**RE: Precision Eye Center
7521 Alameda Blvd. NE
Grading & Drainage Plans
Engineer's Stamp Date: 04/19/23
Hydrology File: C19D070**

Re: C19-D070 Responses to Hydrology Comments received on 3/16/2023

**RE: Precision Eye Center
7521 Alameda Blvd. NE
Grading & Drainage Plans
Engineer's Stamp Date: 02/28/23
Hydrology File: C19D070**

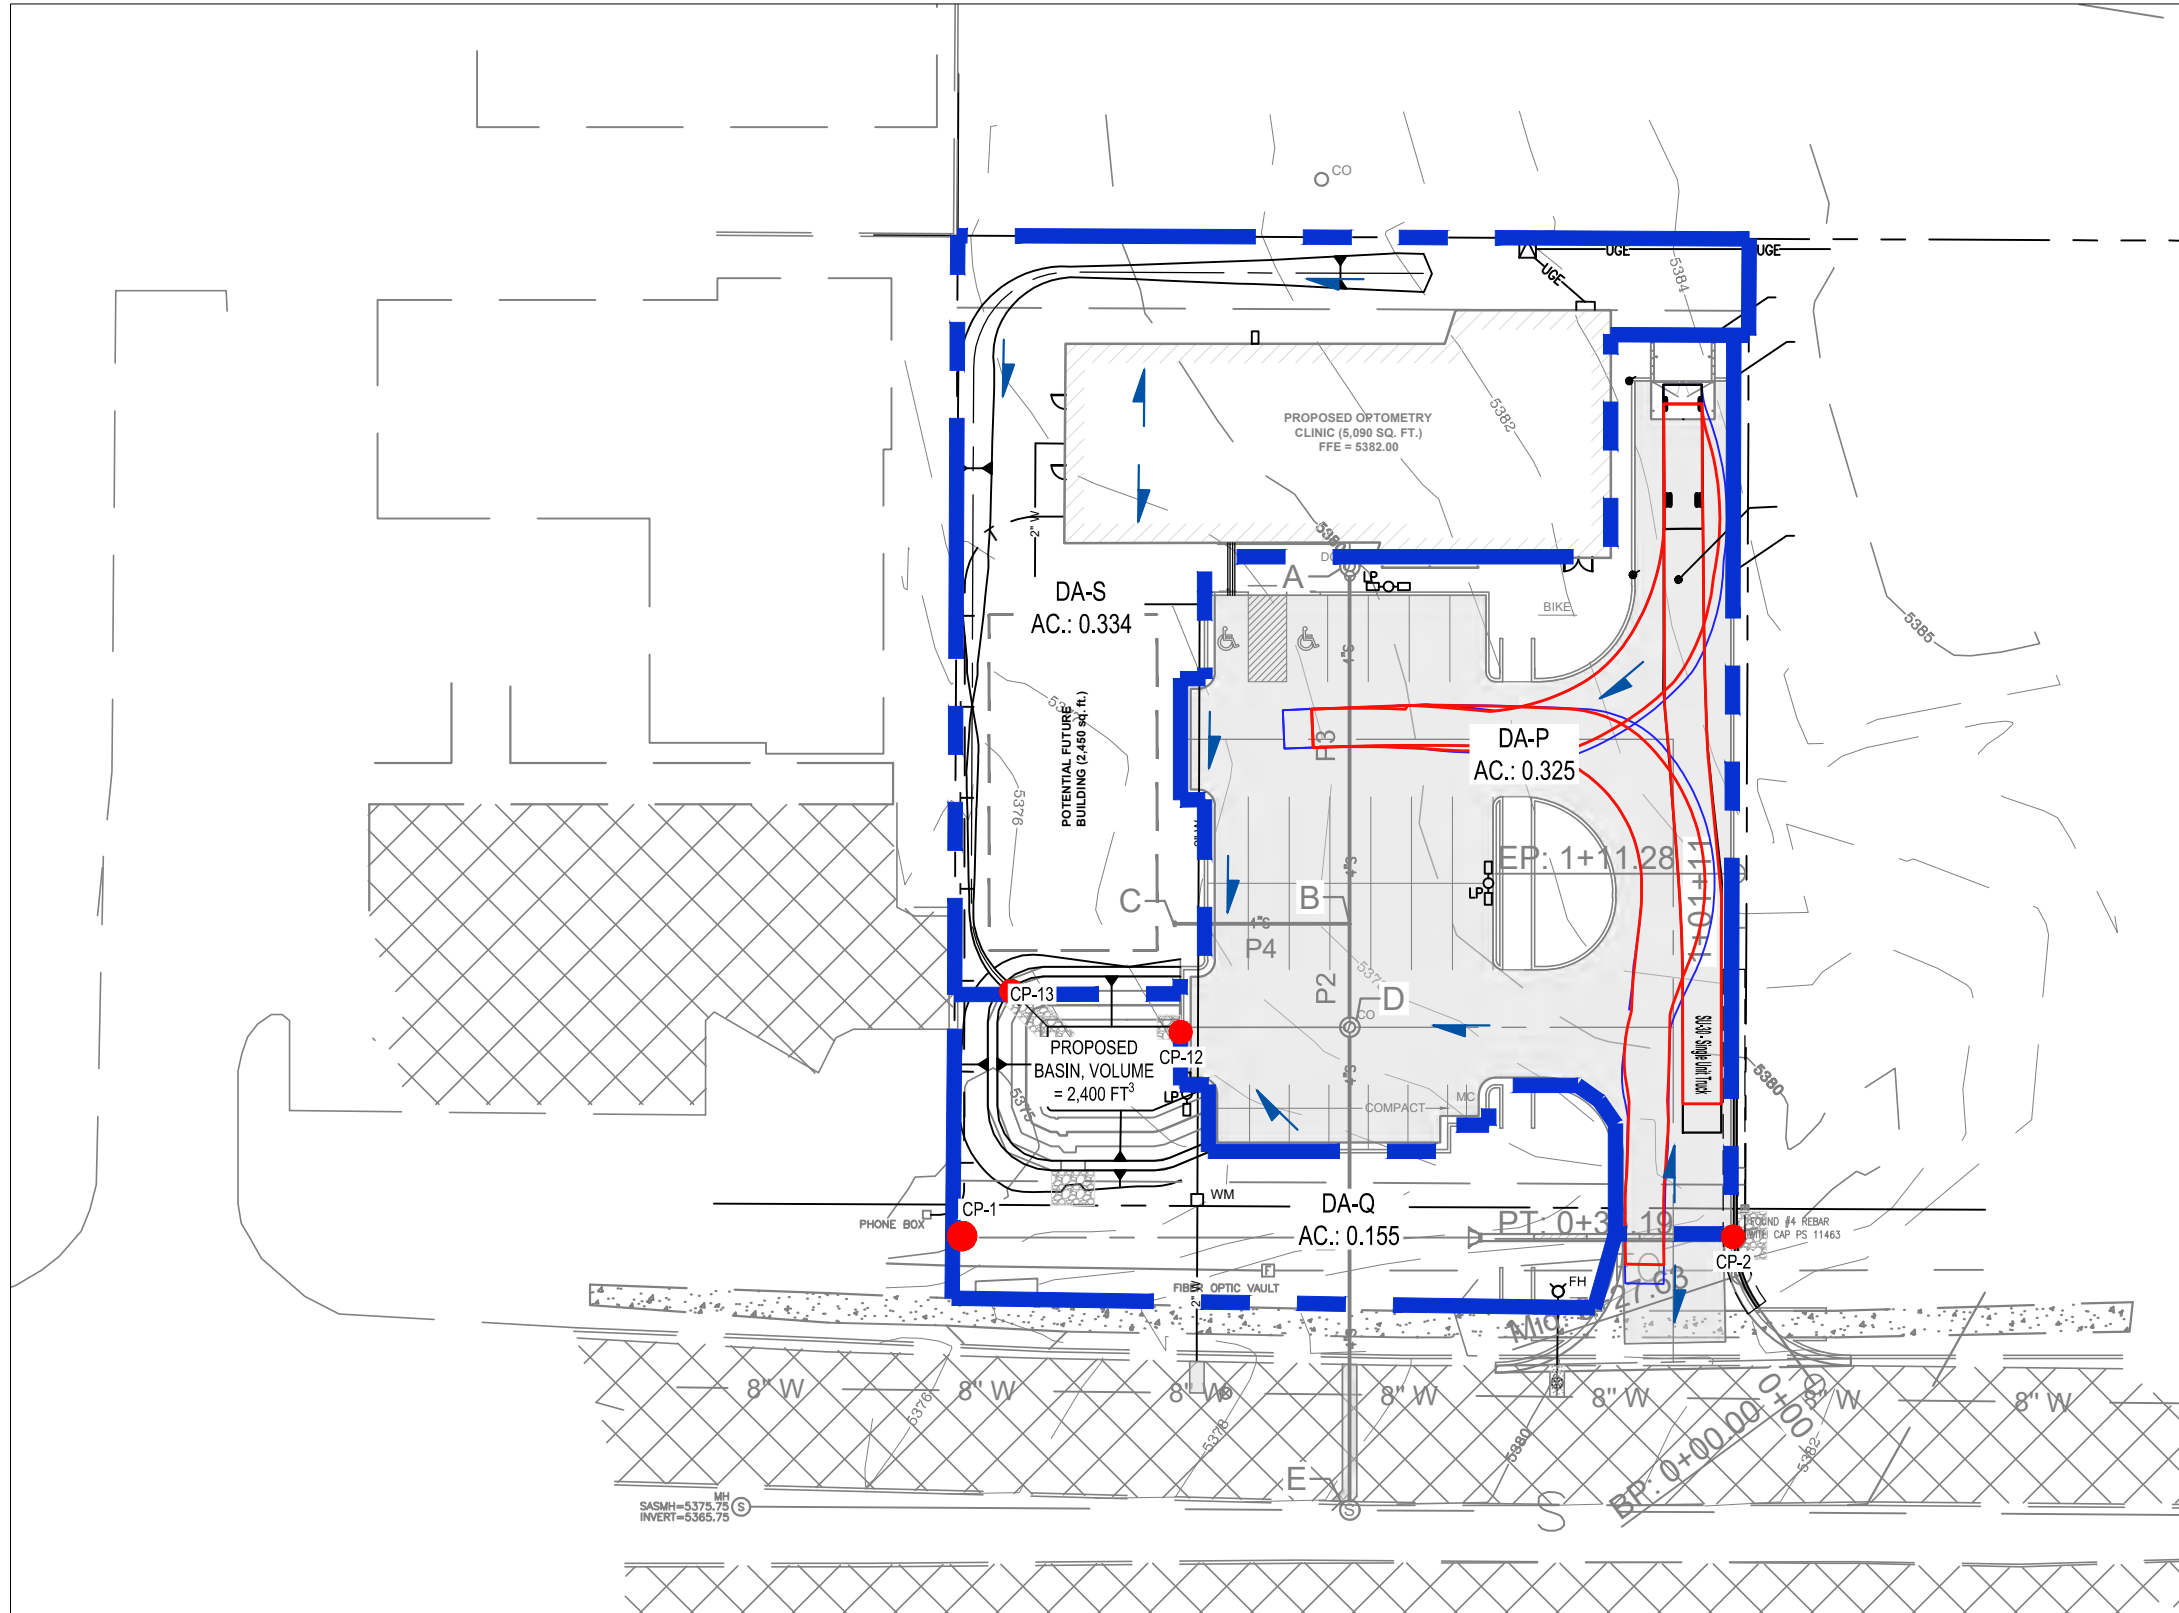
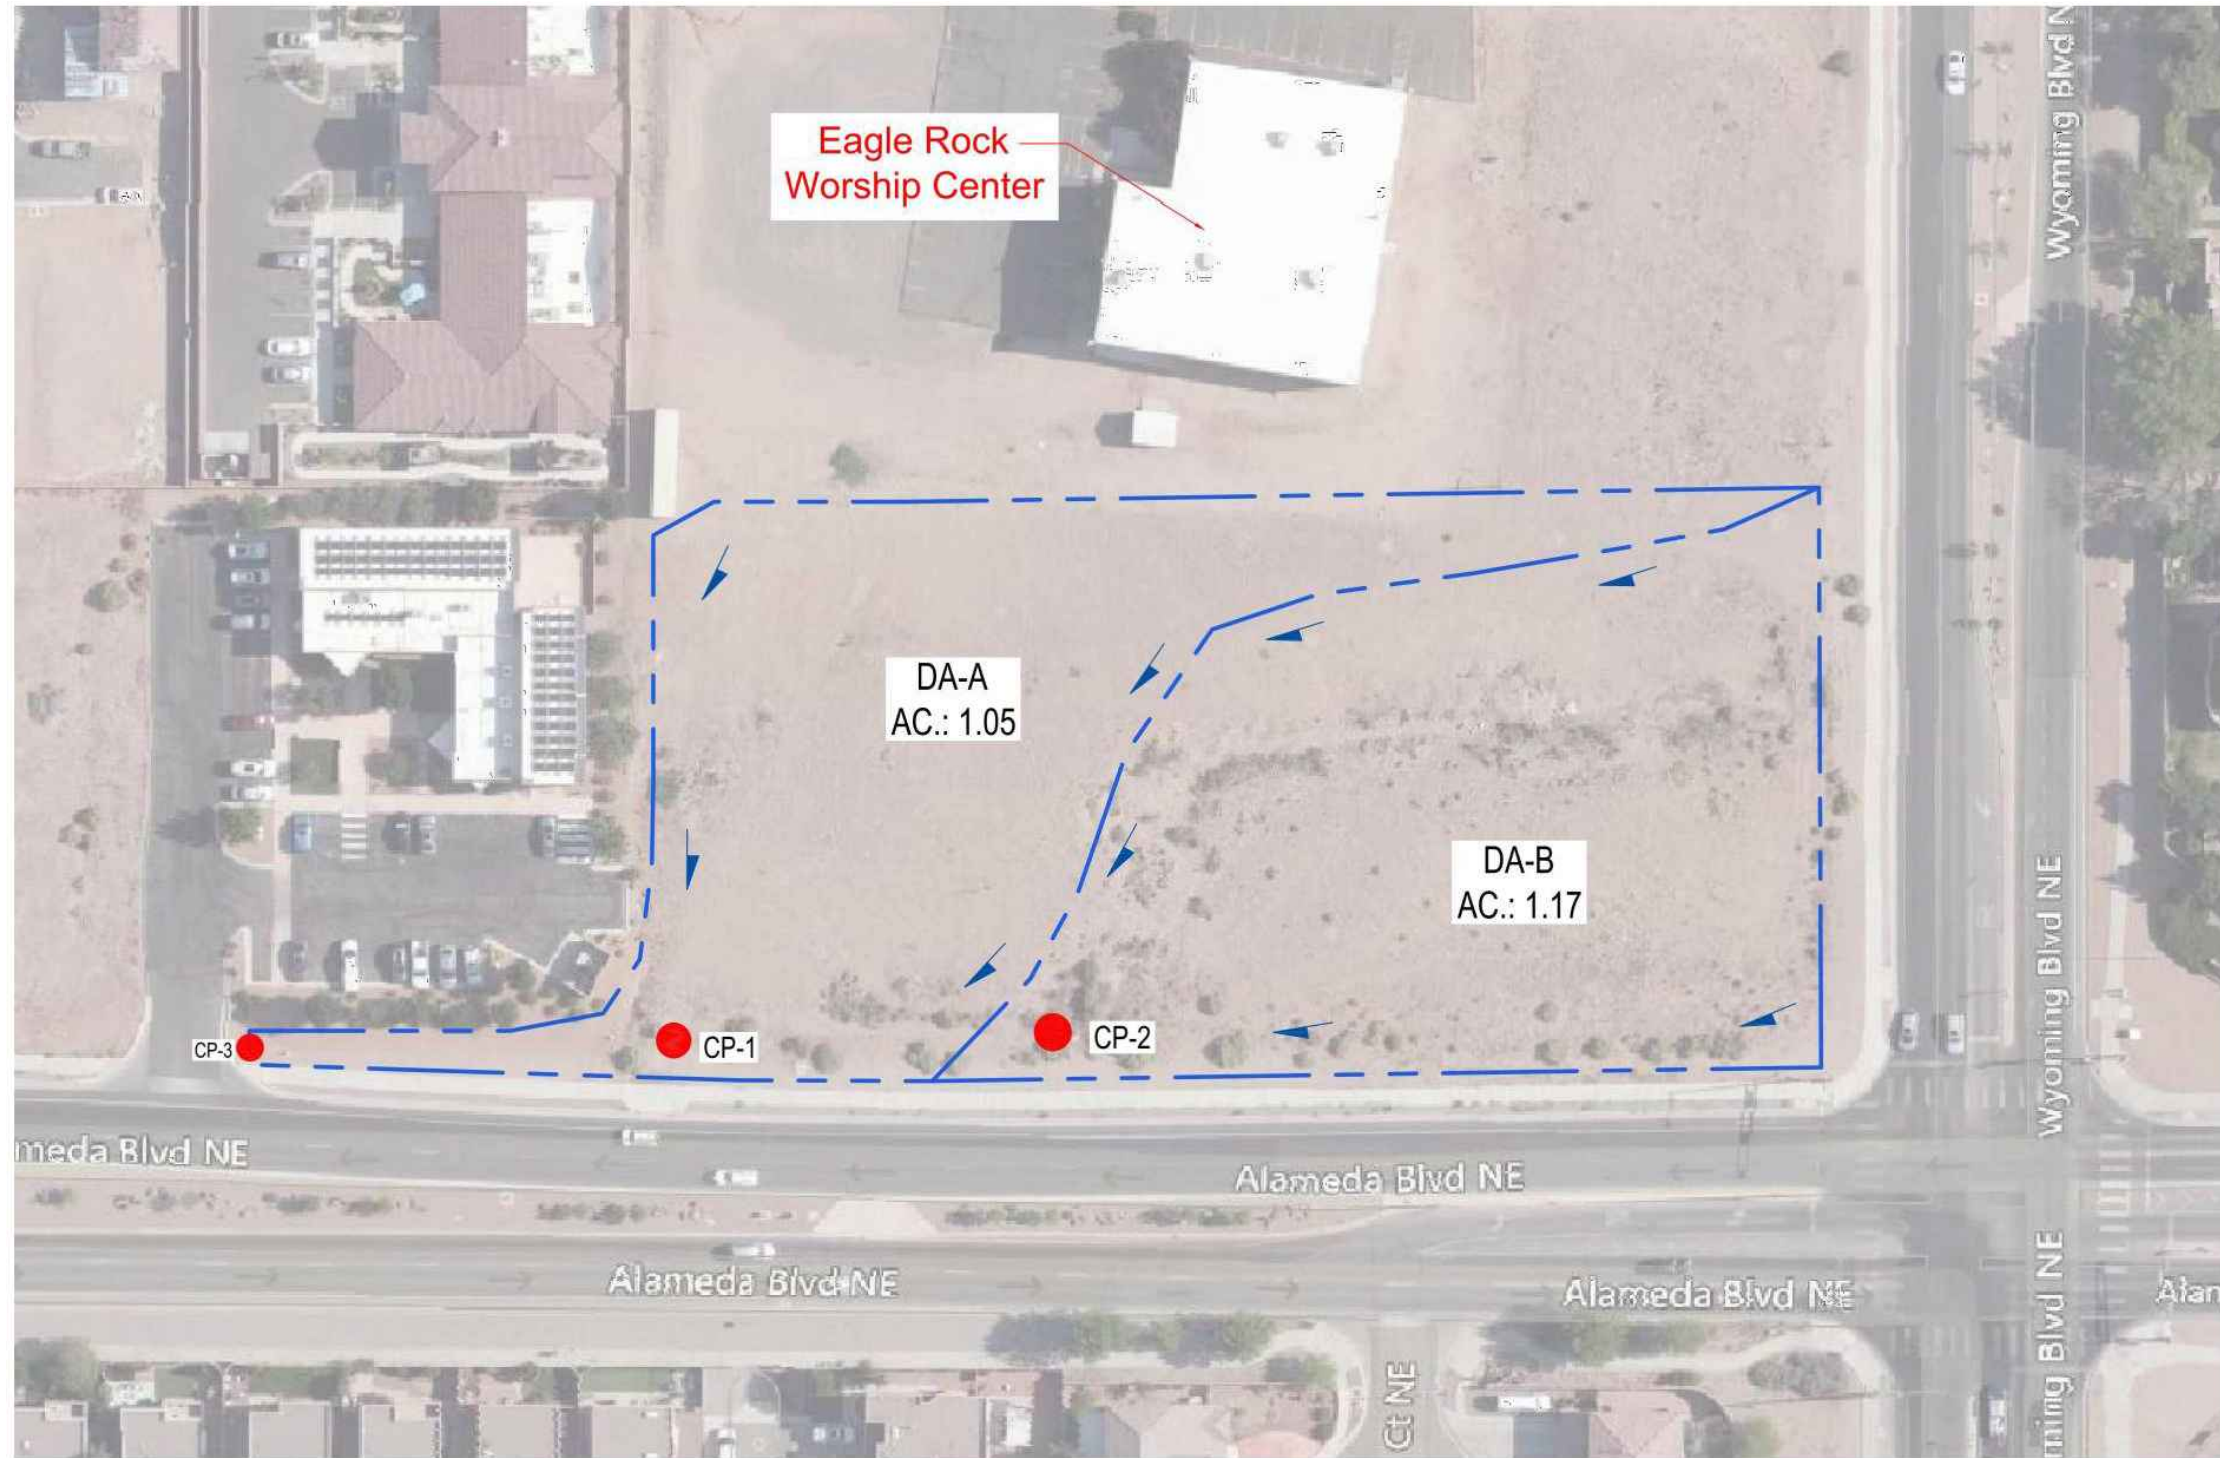
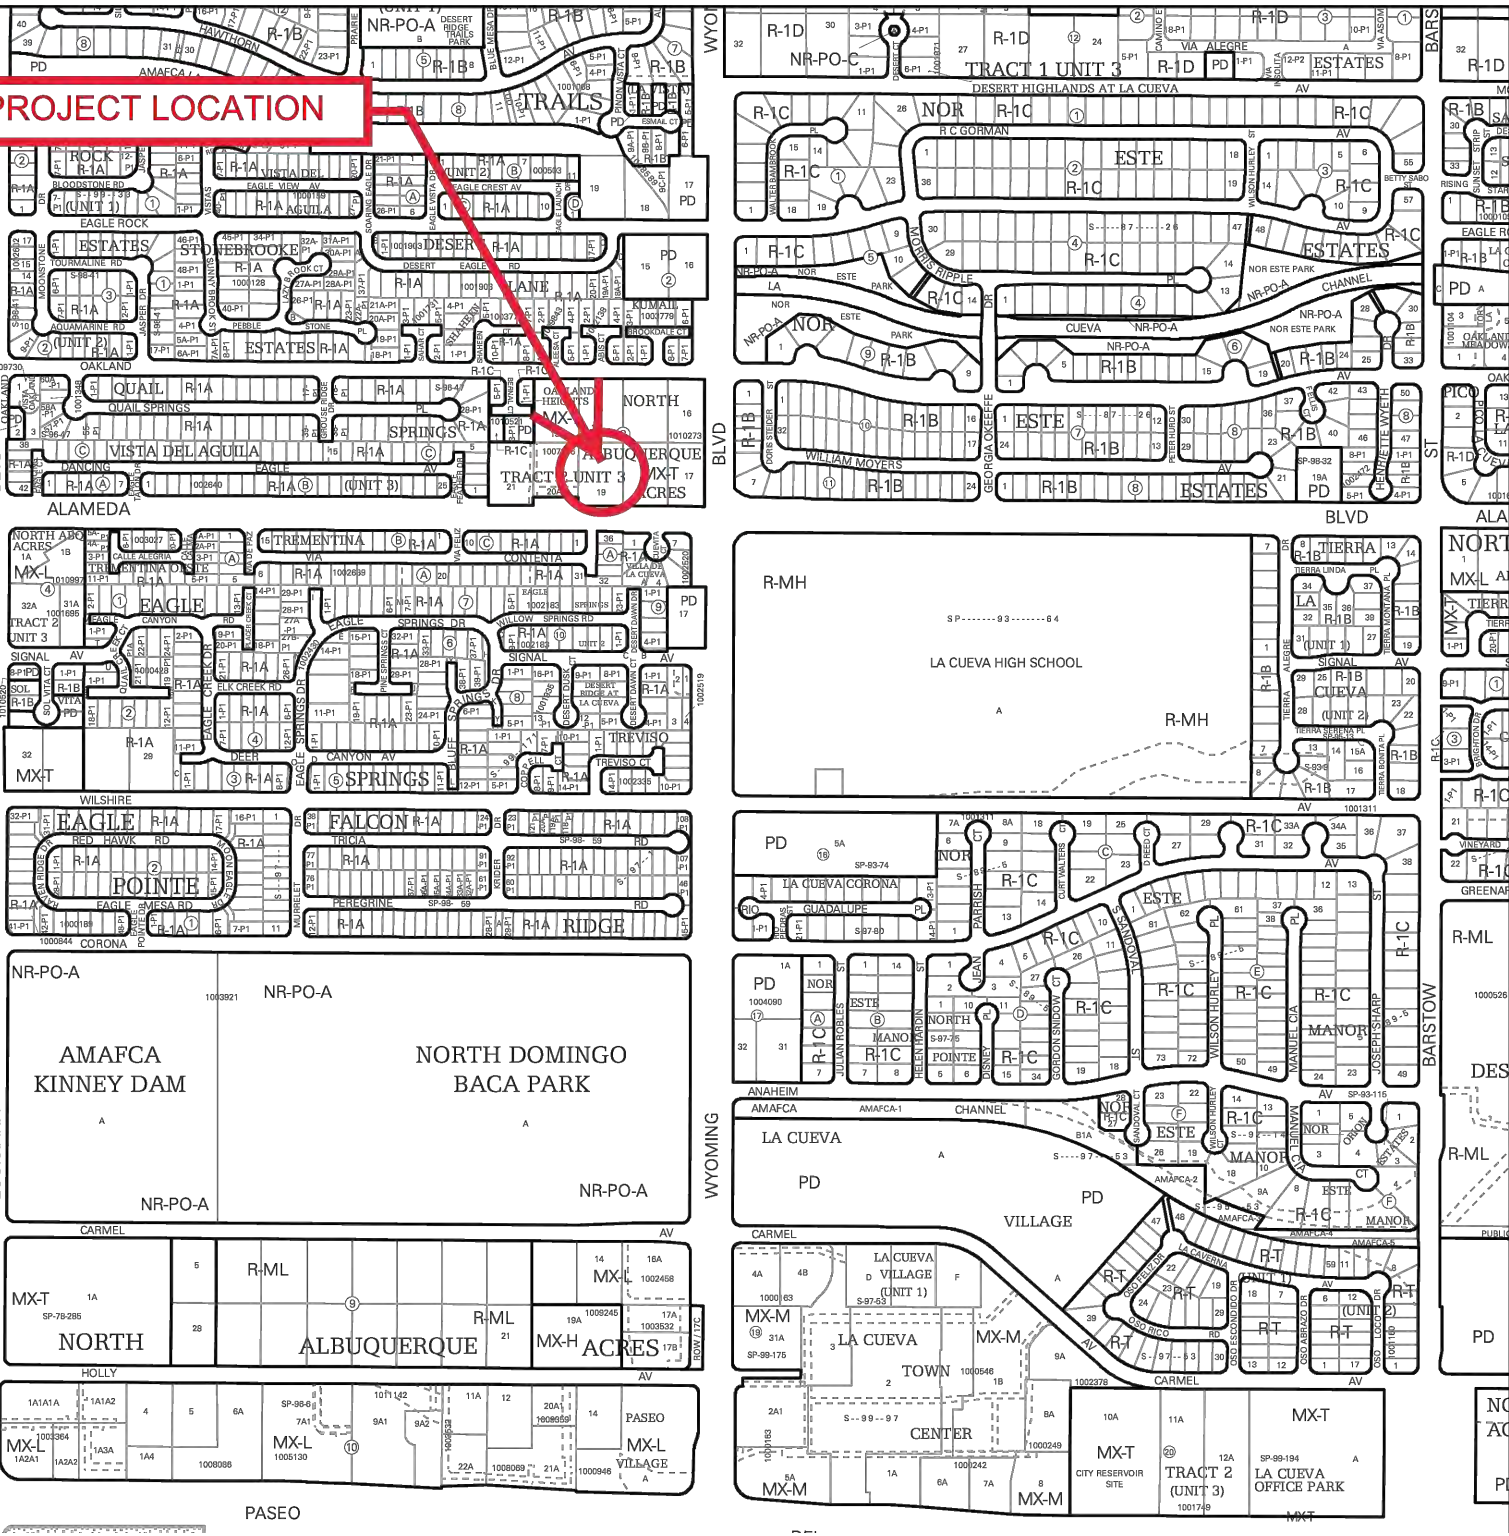
4. On Sheet 103, under the Existing Conditions. Please state, "Project is with North Albuquerque Acres Master Drainage Plan by Resource Technology, Inc. October 1998 which this site has an allowable discharge rate of 3.60 cfs/ac". **added**

6. On Sheet 103, the Stormwater Quality Pond volume is incorrect. Per DPM Article 6-12 Stormwater Quality and Low-Impact Development for the sizing calculations, 0.42 inches for new development sites and 0.26 inches for redevelopment sites. This site is a new development and not a redevelopment. **SWQV pond and calcs revised using 0.42 in.**

8. On Sheet 103, please provide the weir calculations, per DPM Article 6-16(A), for the curb cuts and sidewalk culverts. A coefficient of 2.7 is typically used for the weir equation $Q = CLH^{2/3}$ **Weir equation added to plan**
9. On Sheet 103, please provide a cross section of the SWQ pond with the bottom of pond elevation, top of pond elevation, and SWQ water surface elevation. **X-section added**
10. On Sheet 102, please provide the Benchmark information (location, description and elevation) for the survey contour information provided. **Benchmark info. added**
11. On Sheet 102, please provide the SO-19 Standard Notes, latest version. **added**
